ENG-CDR22008-R6-FDR Redlines.pdf Markup Summary

SEE ANNOTATED FIRM 08041C0552G

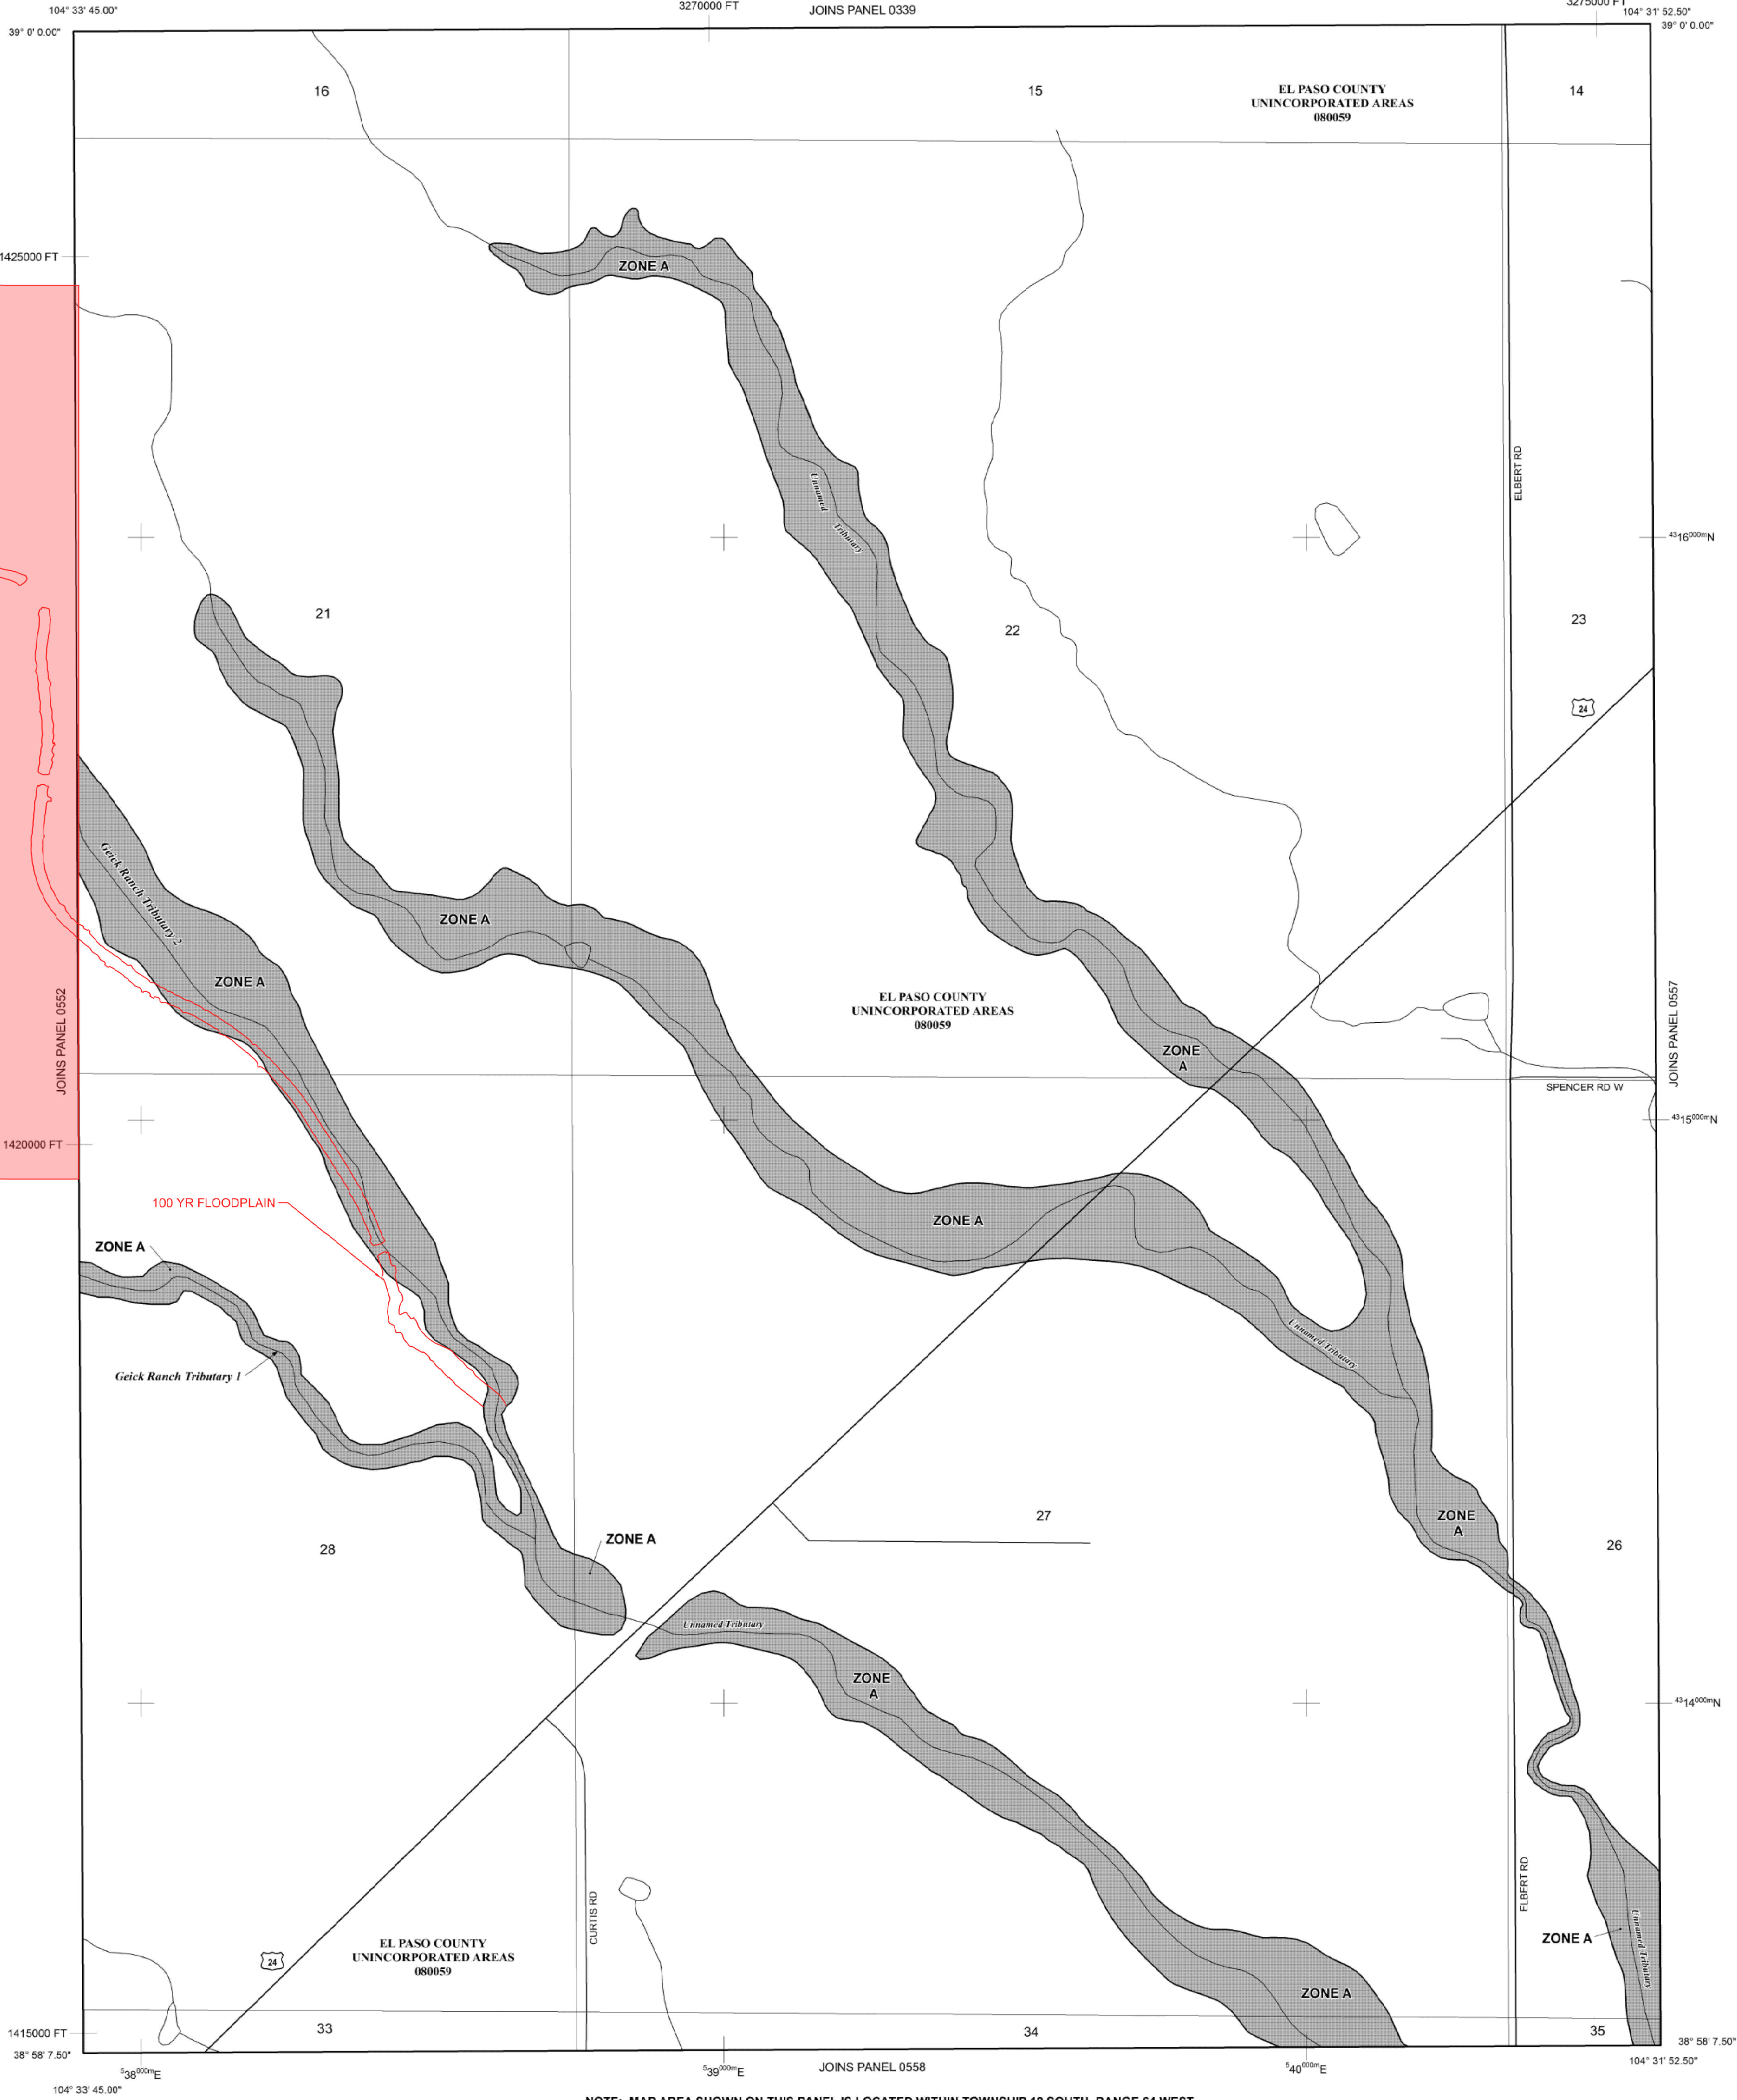
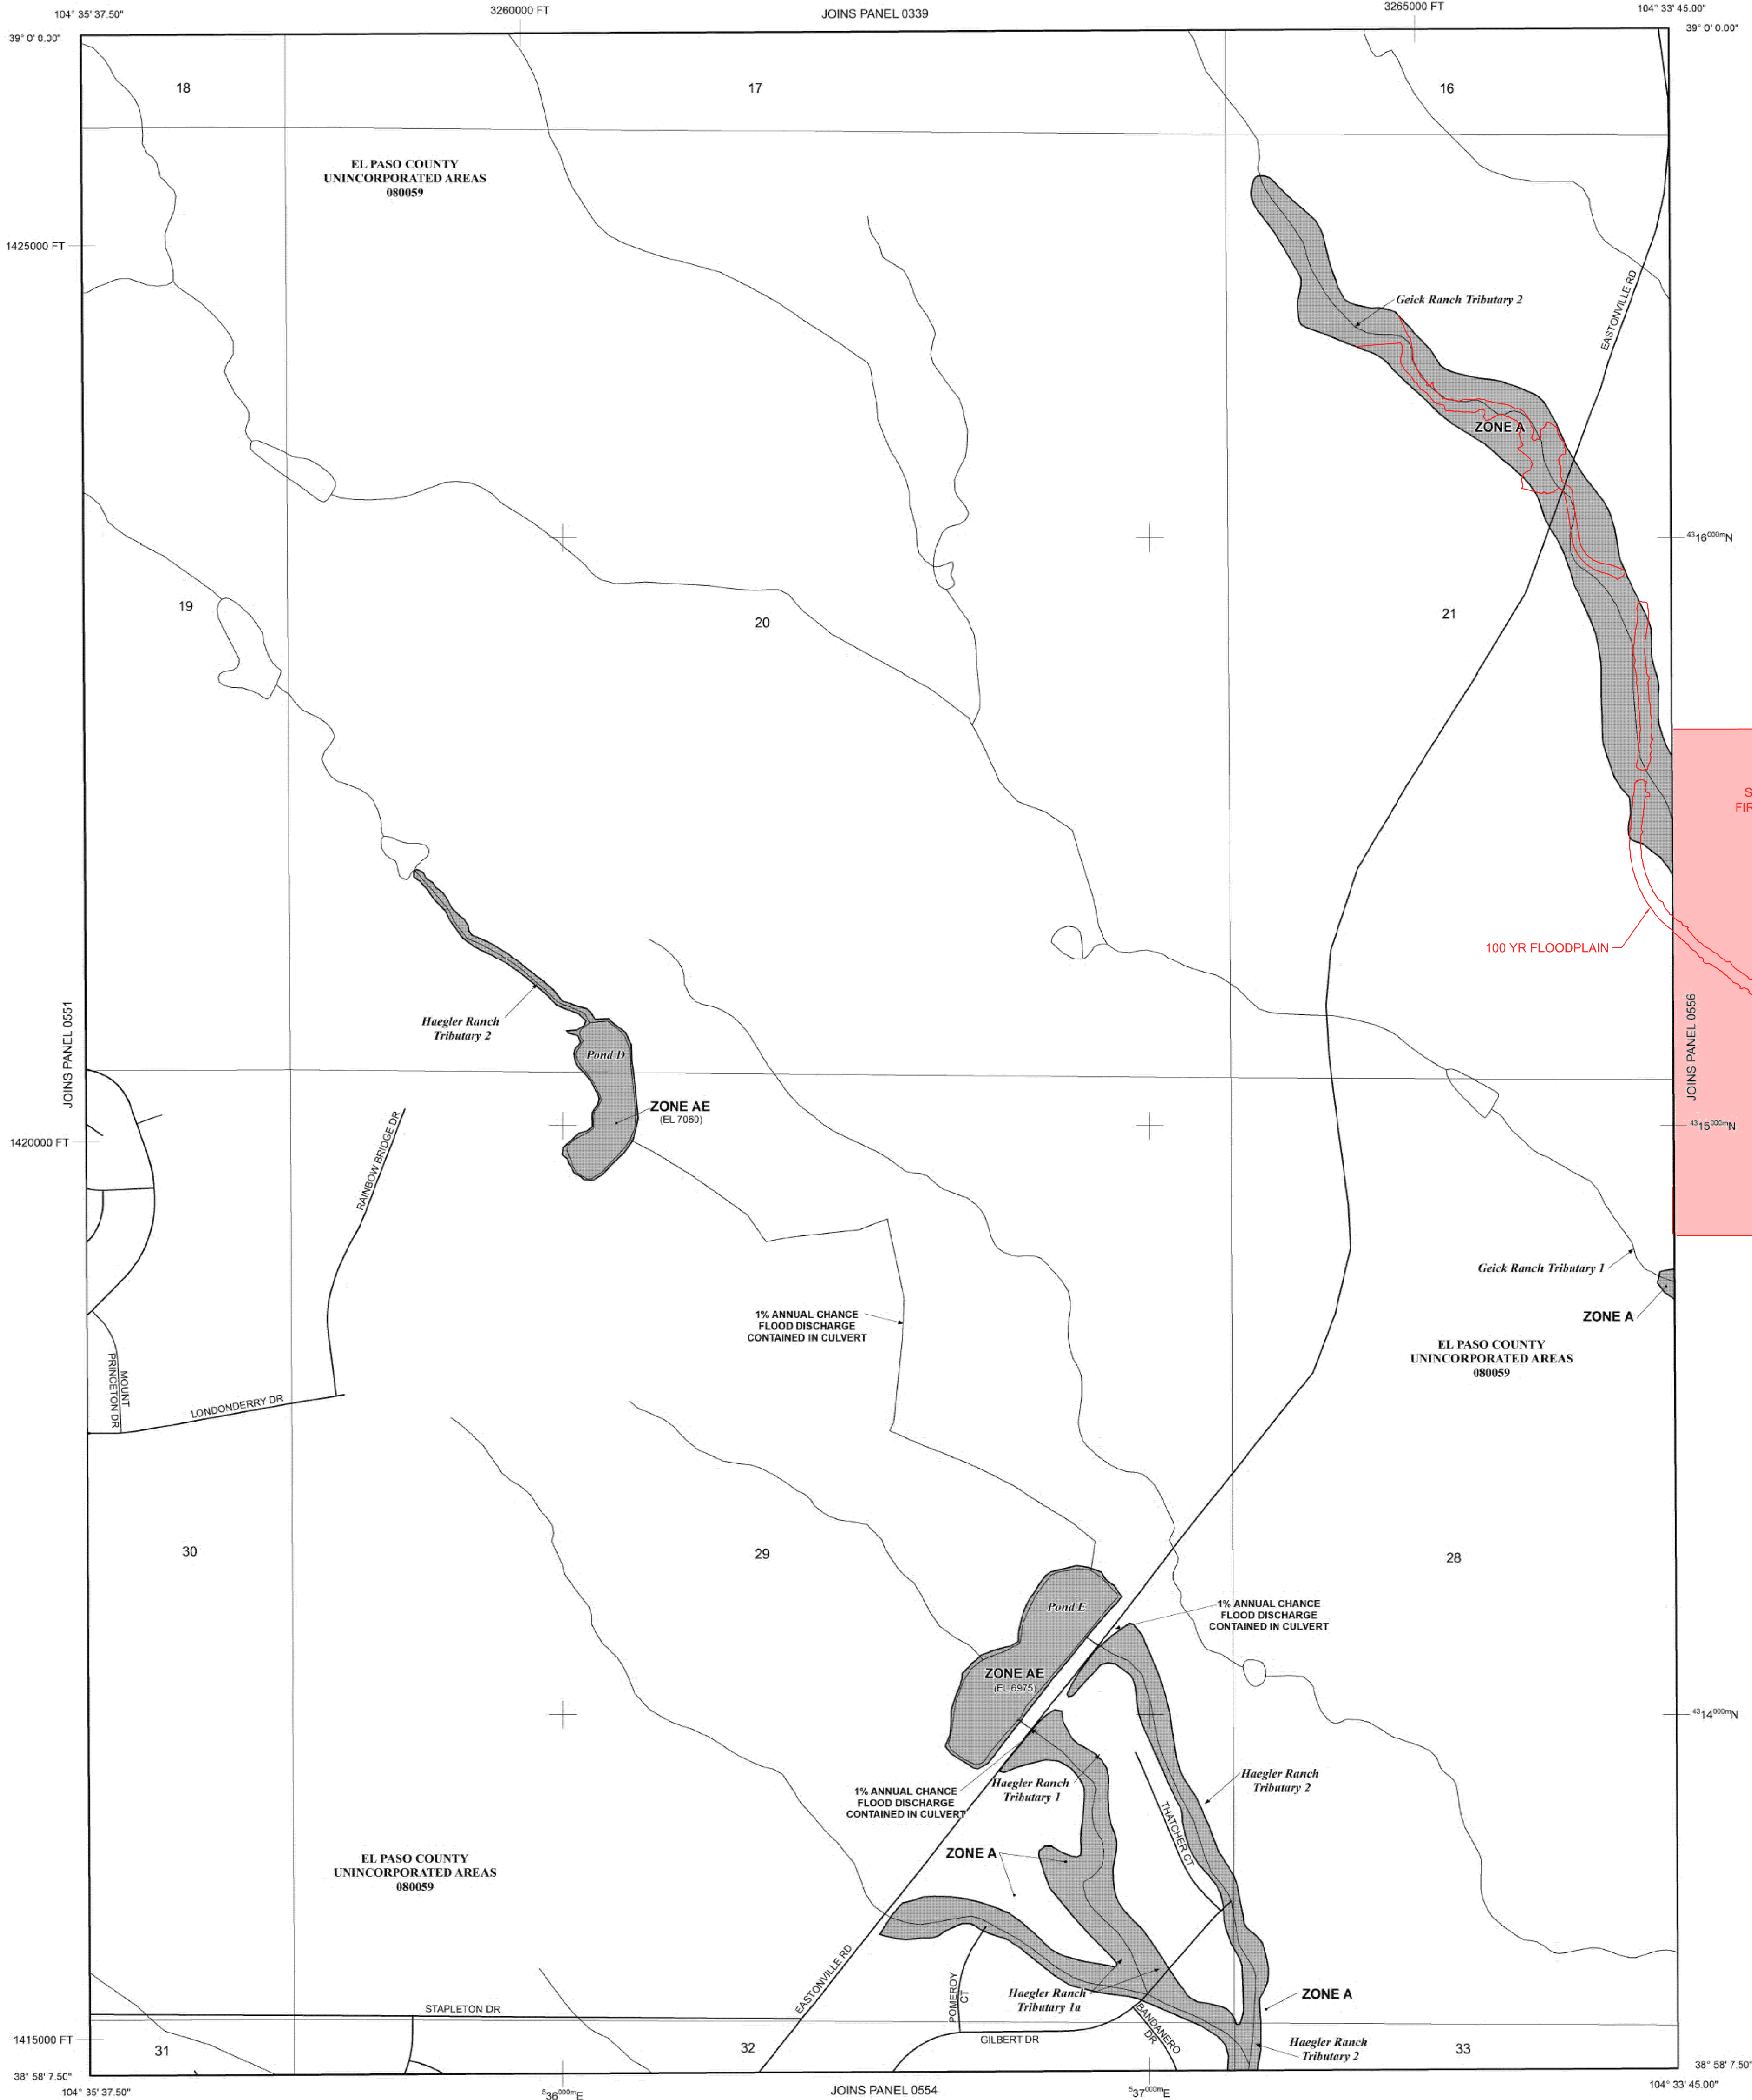
Unresolved: Provide copy of [current] floodplain map in appendix.

Provide copy of current floodplain map in Appendix A.
